Rezoning Transportation Analysis
Petition Number: Insert Zoning Petition #2020-182
General Location Identifier: Tax ID 08019306

Revision Log:	Date	Description
	01-21-21	First Review (WB)

Transportation Summary

1 SITE PLAN

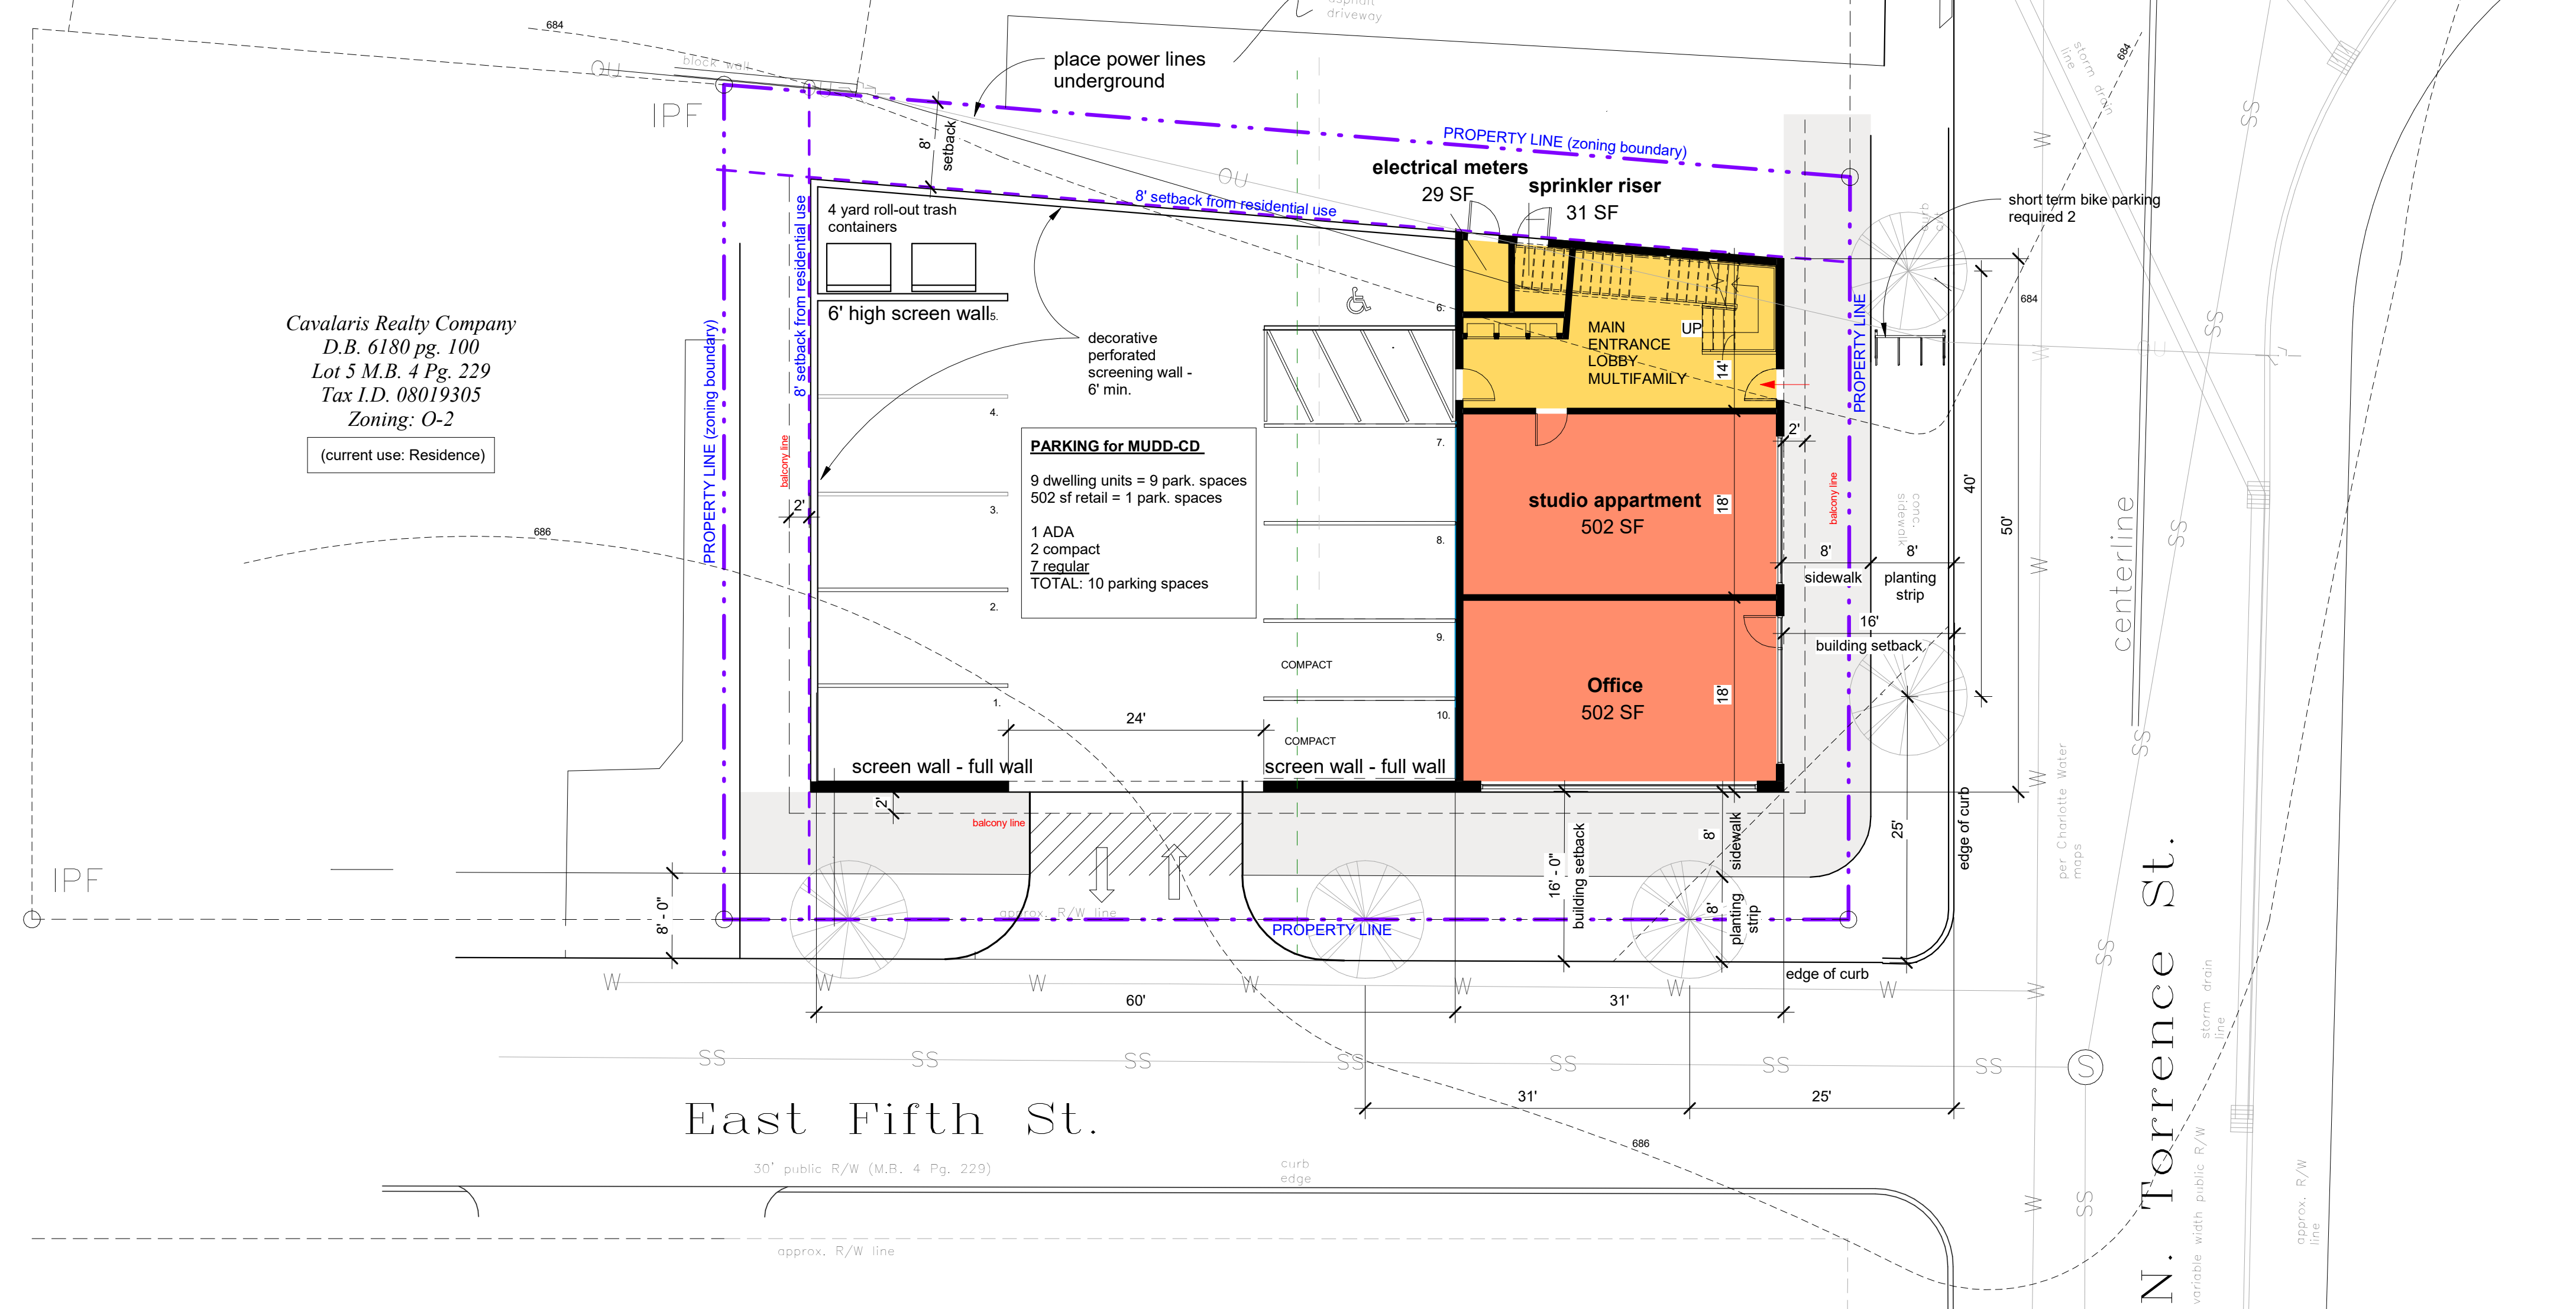
1. **Curbline:** The proposed zoning district has a setback measured from back of the existing or proposed future curbline.
 - a. **East 5th Street:** Location of curb and gutter needs to be constructed at 20.5' from the centerline.
 - b. **Torrence Street:** Location of curb and gutter needs to be constructed at 20.5' from the centerline.

Label and dimension the curb and gutter from the centerline for each road on the site plan.

3. Revise site plan and conditional note(s) to dedicate 28.6' right-of-way from the road centerline. The site plan shall label and dimension the right-of-way from the road centerline.

4. Revise site plan and conditional note(s) to commit to constructing an accessible ramp on the north quadrant of the intersection of 5th street and Torrence Street per ADA and PROWAG standards.
